DRB Project Case #: 1004829

Subdivision Name: VOLCANO CLIFFS UNIT 2 BLOCK 4 LOTS 1A & 1B

**June 28, 2006
DRB Comments**

RE: Lots 1 & 2, Block 4, Volcano Cliff Subdivision/p&f

PLAT OF
 LOTS 1-A AND 1-B, BLOCK 4
 VOLCANO CLIFFS, UNIT 2
 (BEING A REPLAT OF LOTS 1 AND 2, BLOCK 4,
 VOLCANO CLIFFS, UNIT 2)
 SITUATE WITHIN
 CITY OF ALBUQUERQUE
 BERNALILLO COUNTY, NEW MEXICO
 SECTION 27, T. 11 N., R. 2 E., N.M.P.M.
 JUNE 2006

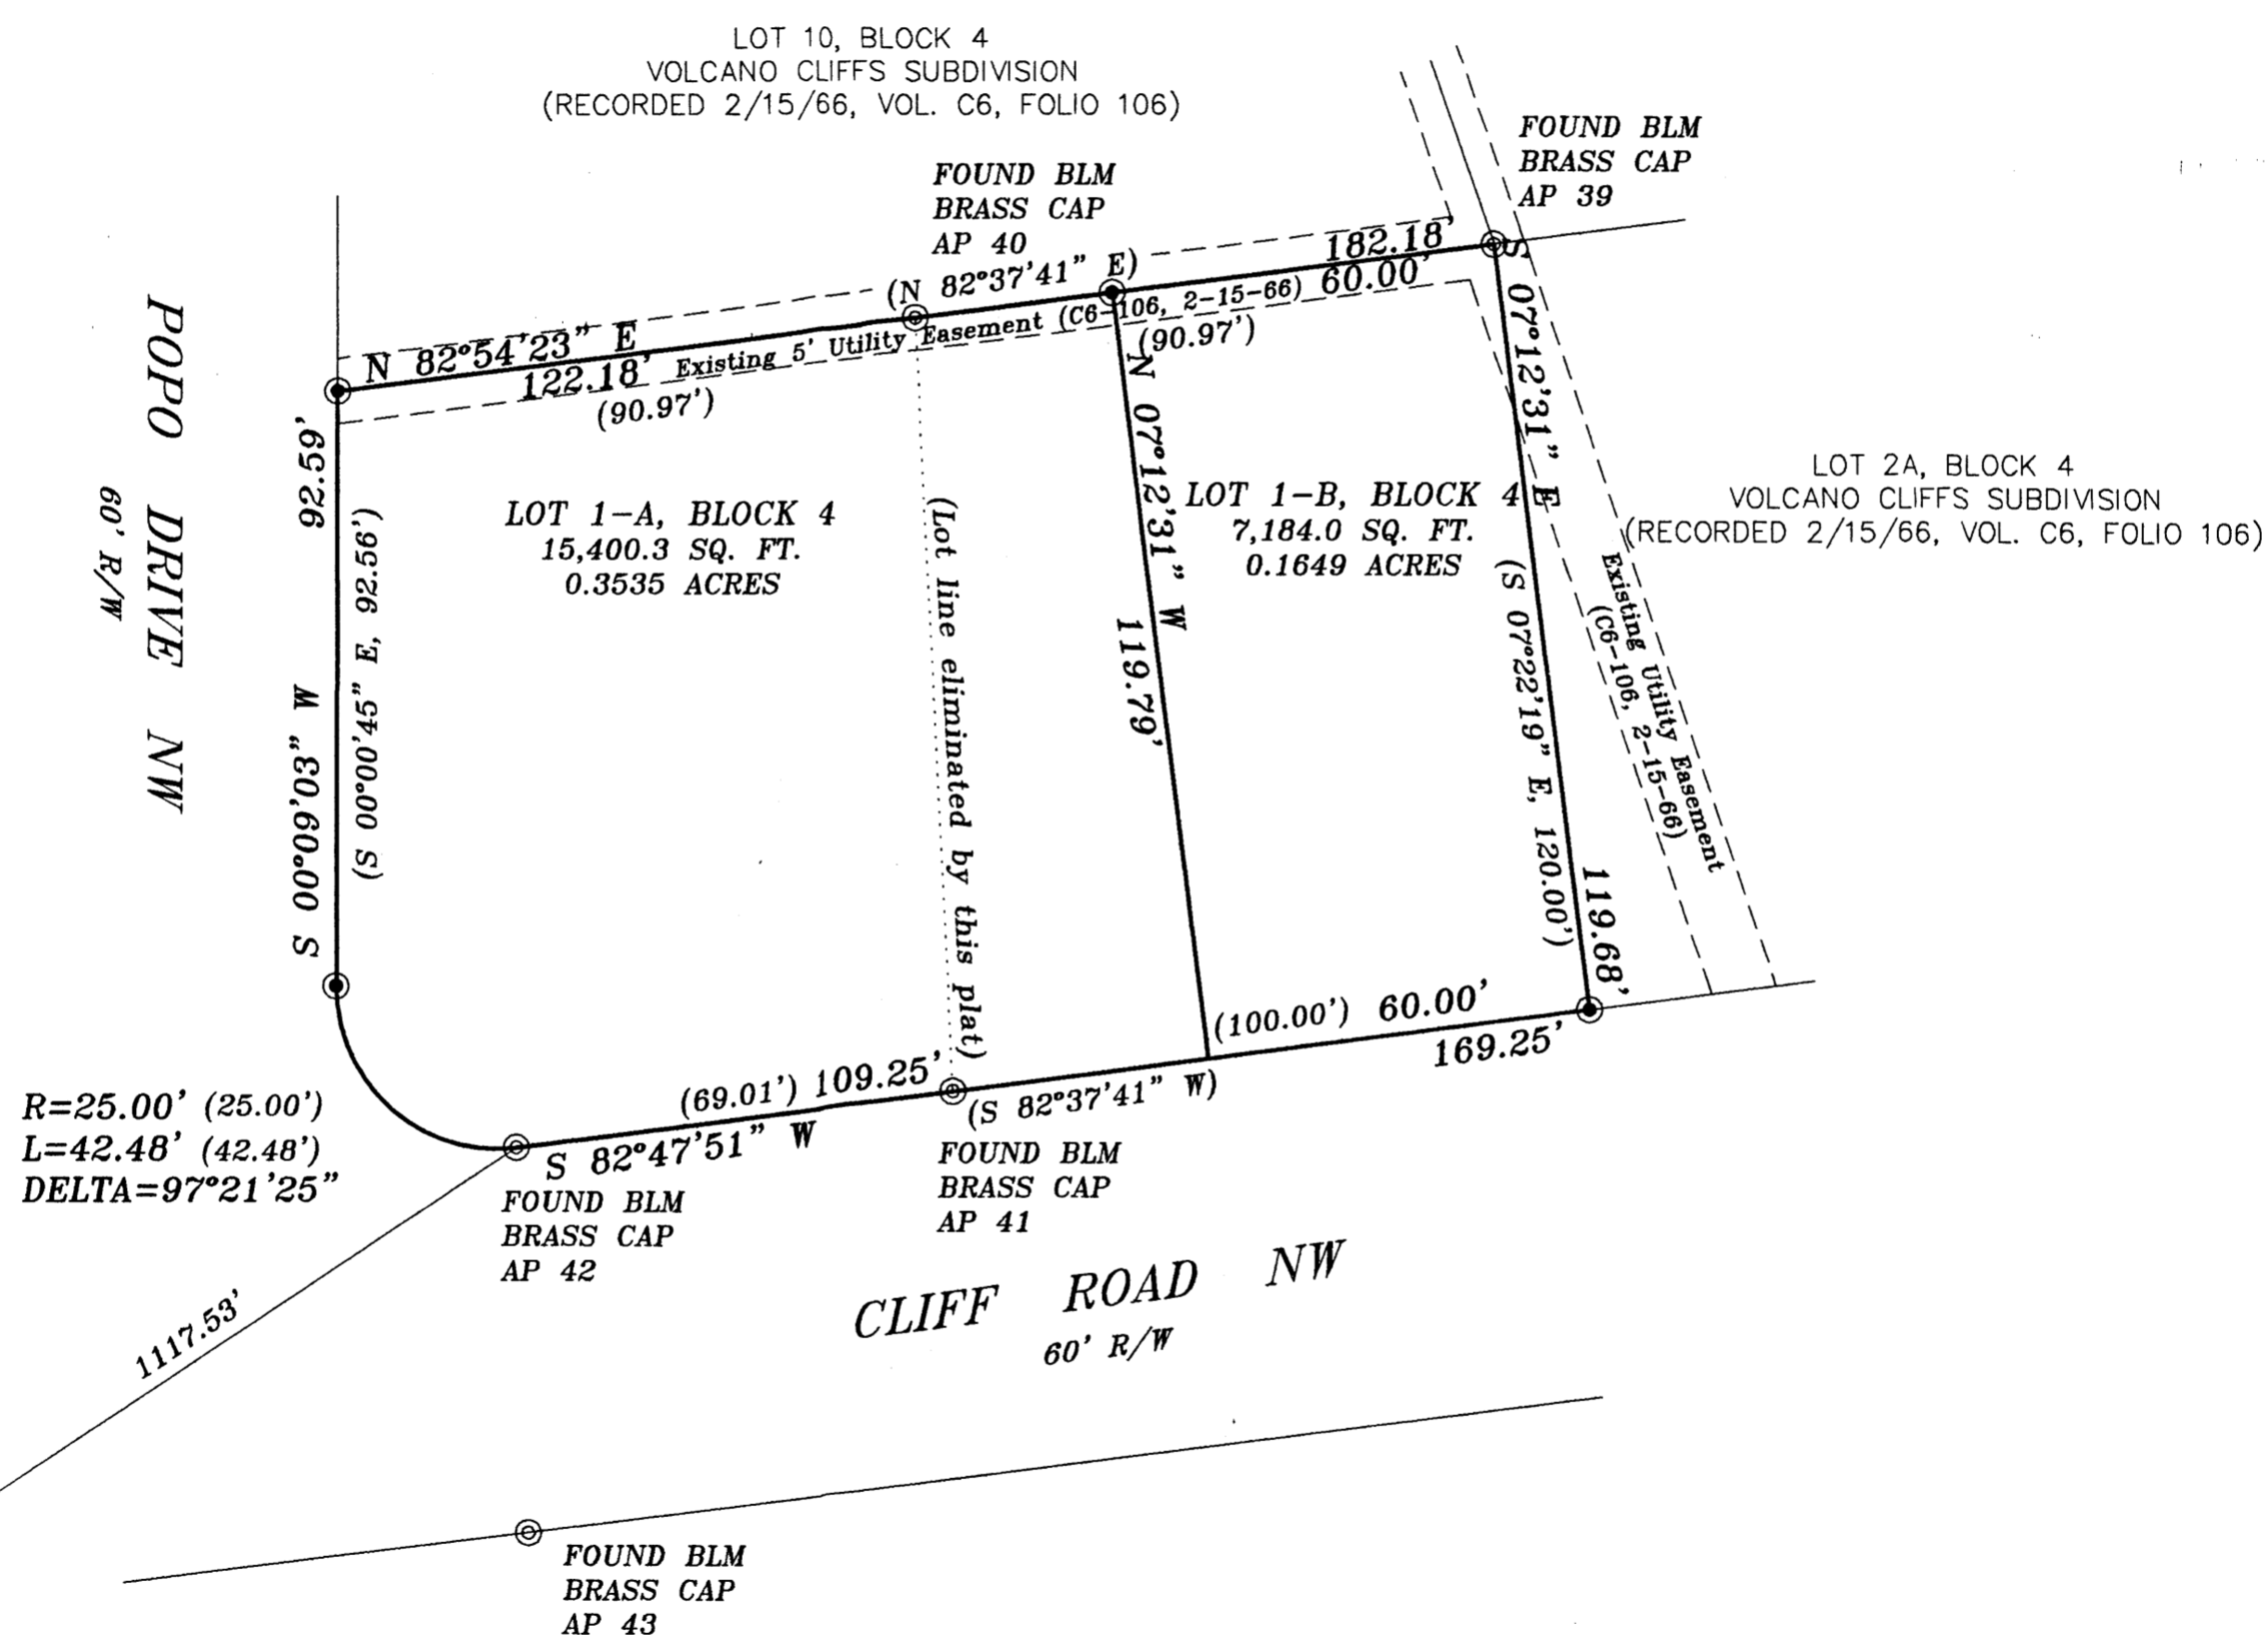
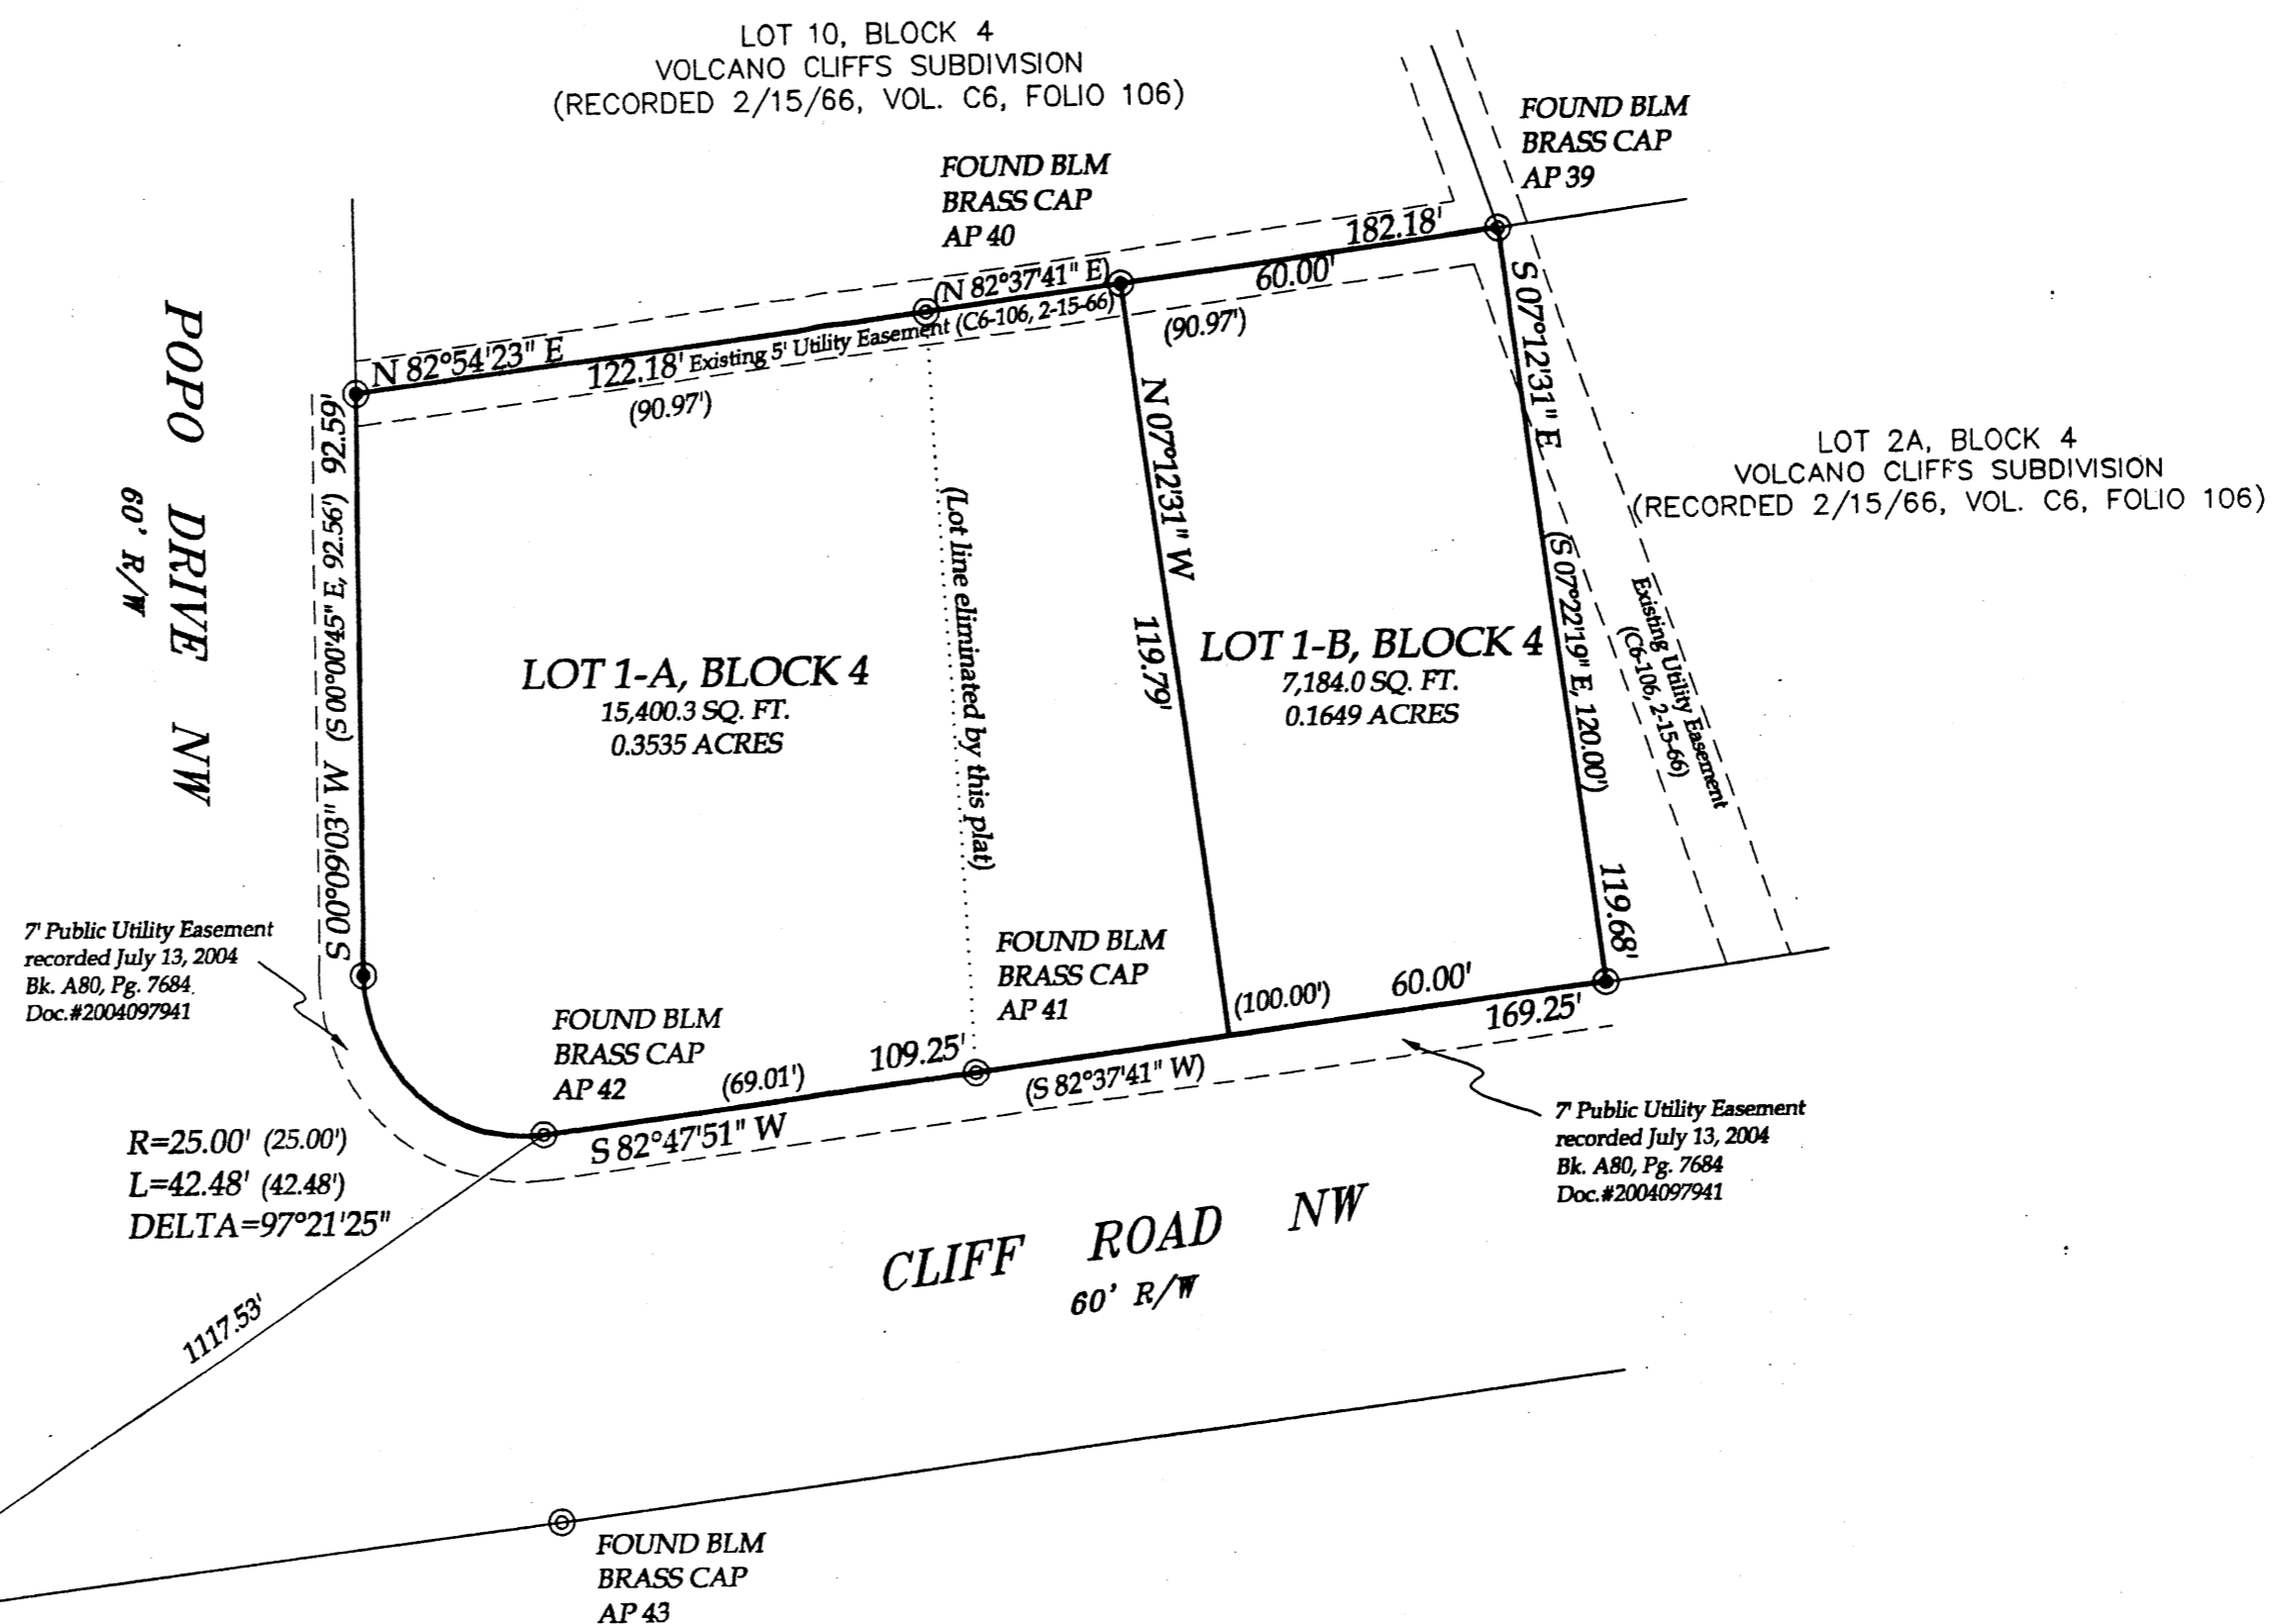
The sketch accompanying this application shows that the 2 new proposed lots will meet the required 6,000 square foot minimum lot size. However, Lot 2 does not meet the minimum 60 foot minimum lot width. If the lot is expanded another 3.1 feet, this will be adequate.
